M4 Junctions 3 to 12 Smart Motorway – TR010019
The Planning Inspectorate,
Temple Quay House,
Temple Quay, Bristol, BS1 6PN

Re: Project - M4 Junctions 3-12: Smart Motorway

'Preliminary Environmental Information Report - November 2014'

Drawing title
ENVIRONMENTAL MASTERPLAN
REGULATION 4(2)(e)
SHEET 16 OF 61
MILL LANE UNDERBRIDGE

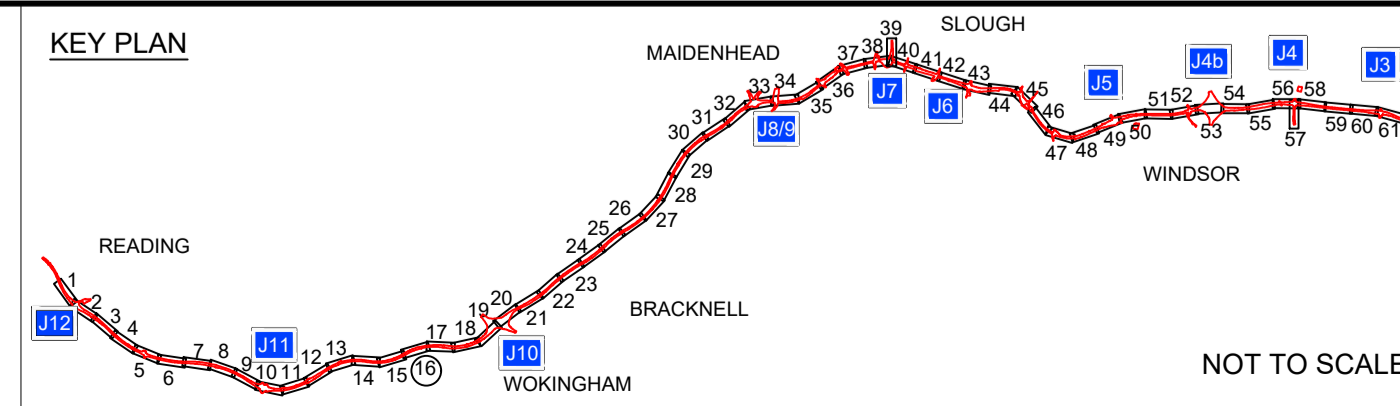
I have estimated the position using drawing M4-PEIR_Drawing_04-1_Scheme-Plan_Sheet-01-19_J12-J10.pdf Sheet 16 and feel that it would mitigate the noise issue more effectively for us if the noise barriers were extended by a minimum 50m to the west on the E/B carriageway, from chainage 49150m to 49200m. In addition we feel the additional low-noise surfacing should also be extended by a minimum of 50m, again on the E/B carriageway from chainage 49140m to 49190m. – It is my understanding that it is now intended to lay low-noise surfacing throughout the scheme.

A mitigation that we feel would prevent this would be to raise the Noise Barrier from the 2m height mentioned under item 12.6.10 (Page 12.36) to 2.4m in height to give us the visual privacy that we should enjoy in our properties reducing the likelihood of truck drivers/passengers being able to see into our properties .
